**Consultation Response from Mike Hibbert,
KC Waste Strategy(Refuse & Recycling)**

2023/91441 31, Chapel Hill, Linthwaite, Huddersfield, HD7 5NJ

**Change of use and alterations to former church (B8-storage) to 9 residential units (C3) and
formation of car park (Listed Building within a Conservation Area)**

Responding Ref: WPS 23-046

Date: April 2023  
 Scale: 1:100 @ A1  
 Job: 22-509  
 Drawing No: P 100 Rev: -

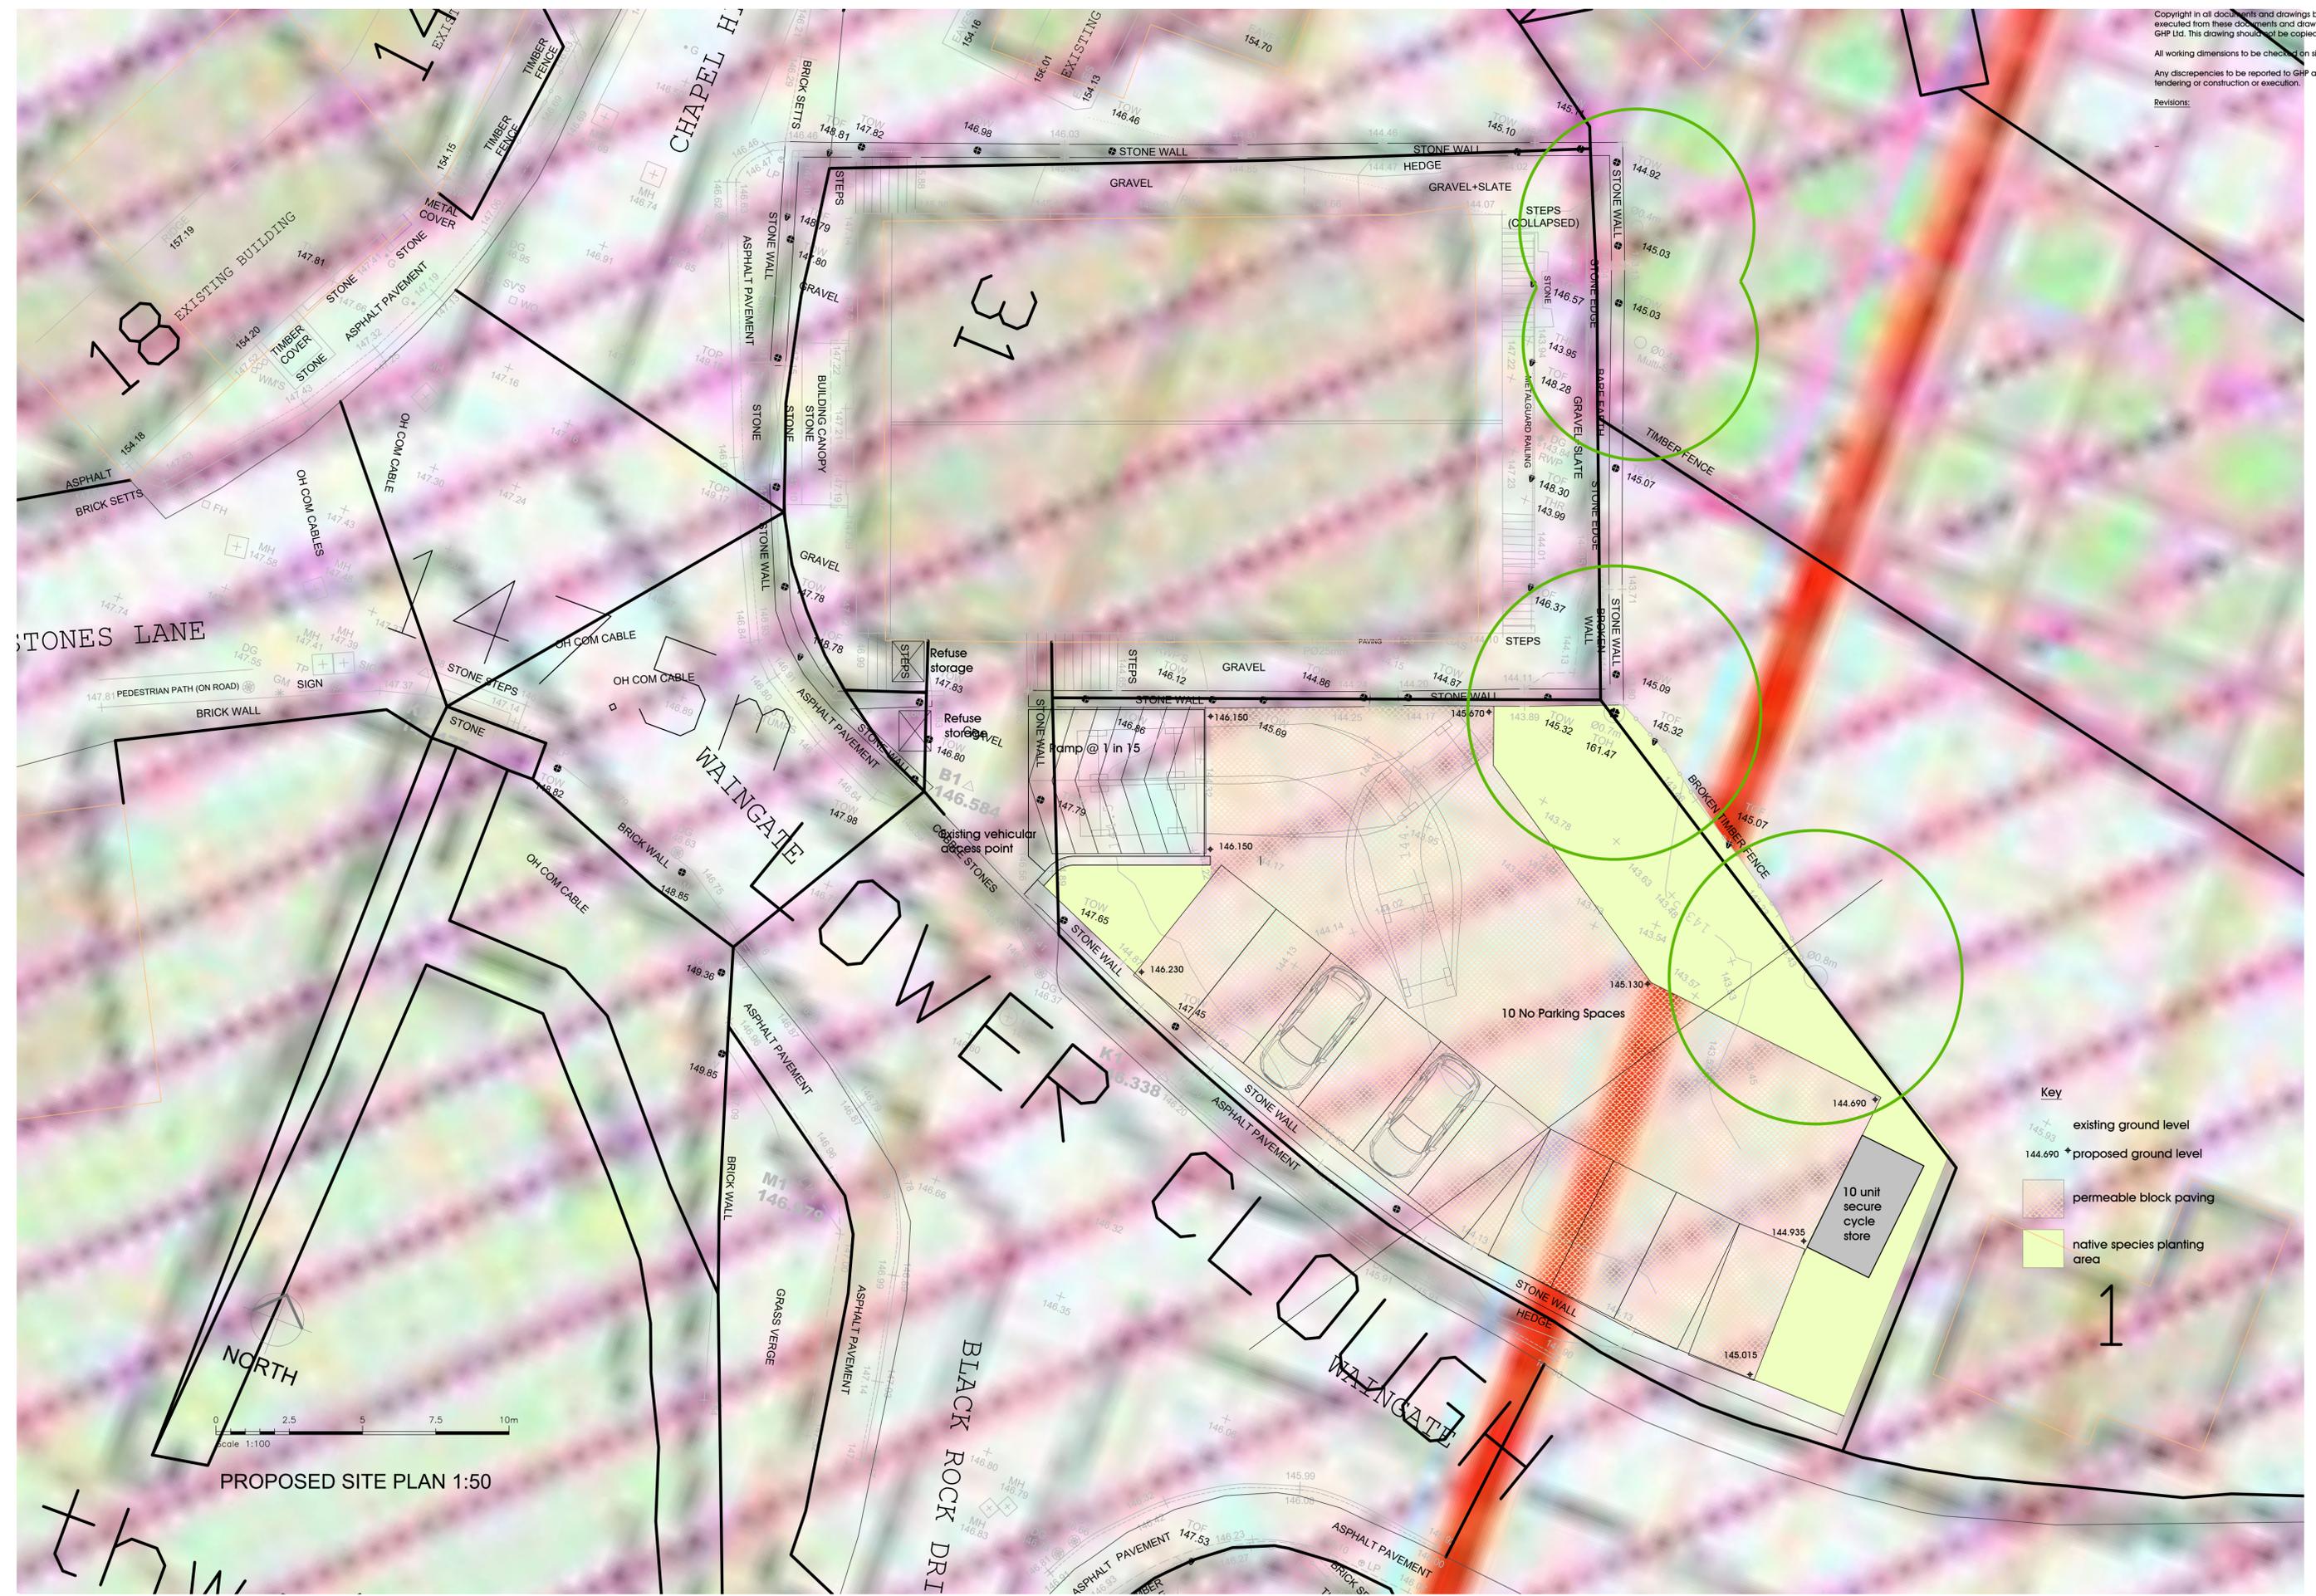
The layout drawing shows the location of a Refuse stores adjacent to the Southern corner of the Chapel building near the proposed access to the new car parking area.

- For 9 apartments individual wheeliebins would not be appropriate. The recommended waste storage provision is approximately 1620ltrs (9X180 litres) for both residual and recycling bins. Appropriate waste storage provision would be 4 x 1100ltrs wheeliebins. (2x Recycling and 2x residual).

- Guidance indicates the floor space for a 1100ltr wheeliebins is 1575mmx1190mm with space to manoeuvre the bins within the store. The current stores as shown are approximately 1350mm x 1080mm and therefore too small. Additional information is required detailing waste storage, containers, capacity and design of the waste storage compound including, screening, surfacing and security. Appropriate standards are detailed in the Kirklees Waste Management Design Guide 2020. Bin store surfaces should be durable and waterproof enough to withstand heavy duty cleaning such as power washing.

- The walk distance from the entrance points of the apartments to proposed bin store(s) should be less than the 30m maximum specified in guidance BS5906:2005. This should be achievable within the site.

- Waste storage should address the fire risk issues presented by large quantities of waste – **it must be either 6m away from the building or be constructed of suitable material to contain and prevent the spread of fire.** See BS5906:2005, Building Regs 2010 Part H6 and CFP-A-E Guideline No 7:2022 F. The current store is too close to the building and could be relocated to be adjacent to the car parking area where the store could also act at the Bin Collection Point (BCP)

- The waste store(s) should be secure to prevent theft, unauthorised use/ fly tipping or rough sleeping. If the doors to the bin store are to have a keypad to secure access these details will be required by the collection staff.

- The bin storage area and access routes to the Bin Collection Point (BCP) should be constructed to withstand point loading and movement, impacts of larger bins over time, and to resist future rutting, pitting, cracking or other such surface degradation that would impair bin manoeuvring. To facilitate loading of full wheeliebins the surface between the bin store and BCP/ highway should be smooth hard surface without kerbs. Maximum drag out distance should be less than 8m. The proposed layout must ensure that parked cars do not obstruct the route between the bin store and loading point.
